From: Amanda Scholes on behalf of Planning.Responses
Sent: 09 January 2020 12:12
To: Planning Scanning
Subject: FW: CEMP - LU/339/19/DOC & LU/340/19/DOC
Attachments: Littlehampton CEMP Rev E Text.docx; STVAL2819121719040.pdf; 01410 - (Lym.) High level Draft Programme.pdf

Dear Michael,
I include my comments re Version E of the Construction Environmental Management Plan in this case.

DELIVERY POINTS 1 & 2.

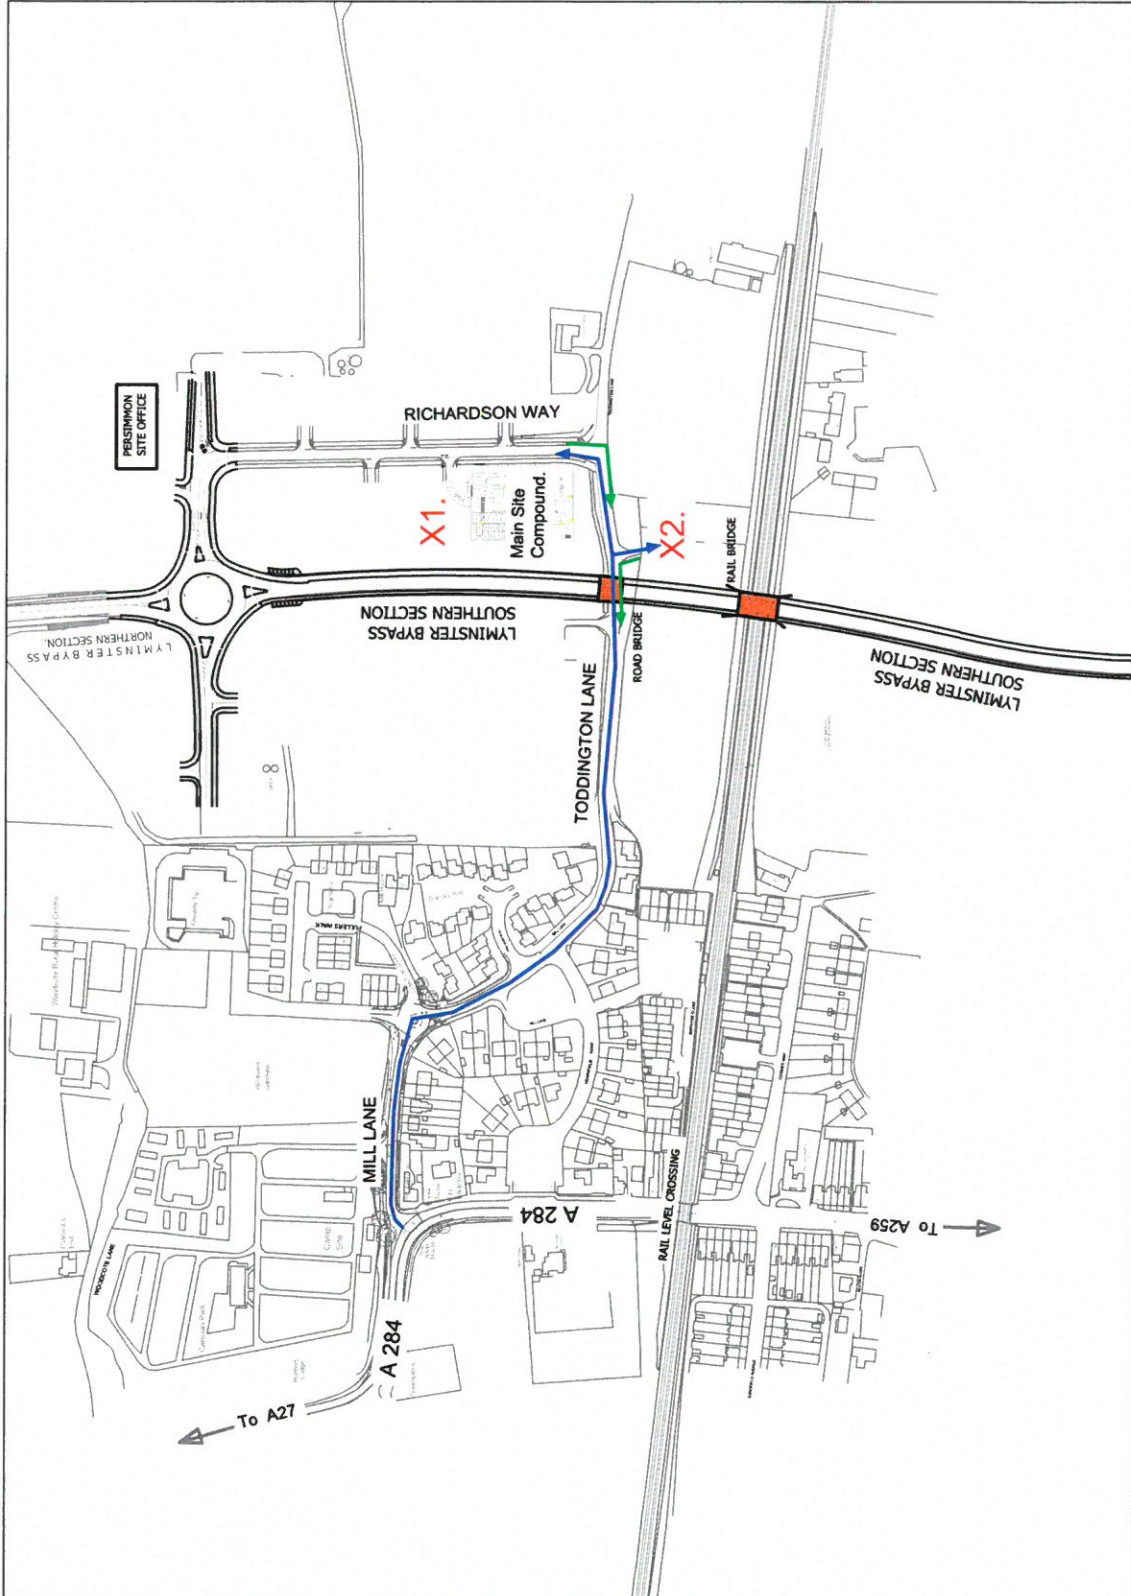
Delivery Point 2: Please note that I have already made comment in respect of the building compound for proposed residential units here which should be removed as far as possible away from existing residential units to the east to prevent noise and dust detriment.

Delivery Point 2 , 3, 4 and 5 : As above, any building compound or delivery point should be removed as far as possible away from existing sensitive receptors to prevent noise and dust detriment.
